Planning Application No: 3/2025/0170

Proposal: Proposed two-storey and single-storey extension to rear and insertion of dormers to front and rear roof slopes.

Location: Brooklands Longworth Road Billington BB7 9TS

2 Proposed Site Plan
1: 200

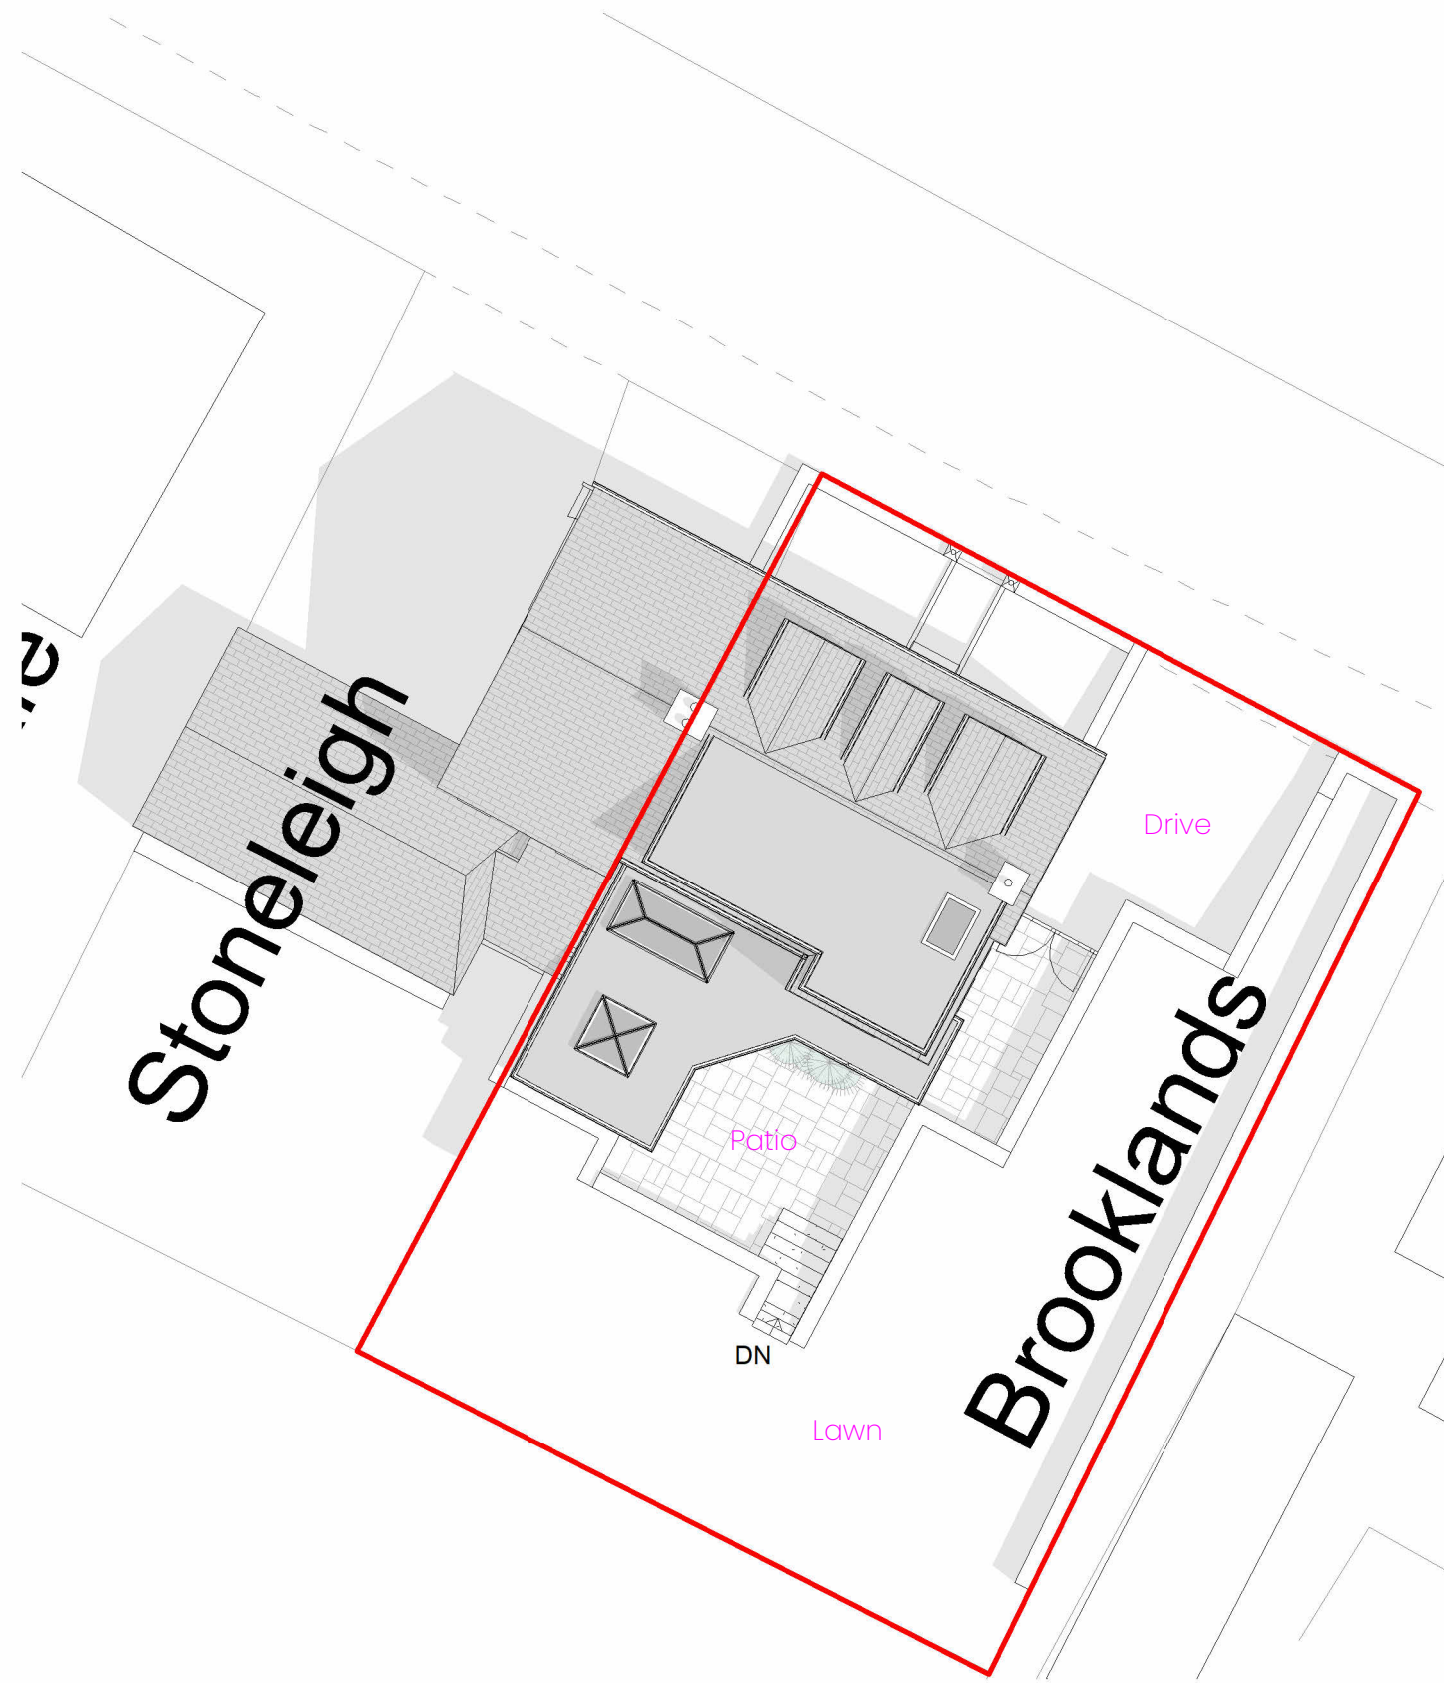
Ref. Design and Access submitted, it is noted there is no change in site area, the single storey rear extension is to accommodate a larger kitchen/dining area, the two-storey rear extension is to provide a new office space, and the dormers include a master bedroom. The proposed bedroom increases the number of bedrooms in the property from an existing three to a proposed fourth, therefore there is an increase in parking standard requirements to three parking spaces for this size of proposal.

There is no change required to the existing access, however, as there is a shortage of one parking space being proposed then a covered cycle store is required for 4 bicycles to promote sustainable forms of transport and aid social inclusion.

- Prior to the first occupation a secure, covered cycle store for 4 cycle spaces shall be provided. Reason: To promote sustainable forms of transport and aid social inclusion.
